Our Ref: R/2022/27
File No: 2022/611104
Your Ref: SSD-35962232

Advice on Environmental Impact Statement – Burrows Road Multi-Level Warehouse – 1-3 Burrows Road, St Peters

Thank you for your correspondence dated 16 November 2022 inviting the City of Sydney (the City) to comment on the Environmental Impact Statement (EIS) submitted for the Burrows Road Multi-level Warehouse proposed at 1-3 Burrows Road, St Peters.

TYPICAL BIO-RETENTION DETAIL
SCALE 1:20

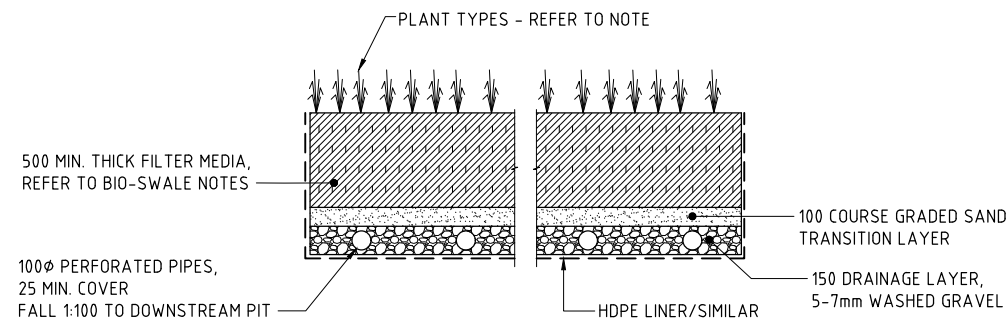
- It is unclear whether the 500mm depth bioretention soil filter media detailed by the engineer needs to be removed and replaced in the future to maintain effectiveness as a drainage device.
- Whether the civil design considers remediation of site contamination in the landscape setback.
- It is unclear if the stormwater design has been coordinated with the landscape design and tree placement and if there is adequate soil volume to support the trees to maturity.

The applicant is requested to submit an engineer's report to clarify the design and requirements including remediation. The City also requests landscape plans at a legible scale, black and white that clearly demonstrate coordination and resolution of the landscape setback, location of trees, levels (IL, RL, TW) and confirm the permeable pavement specification and detail.
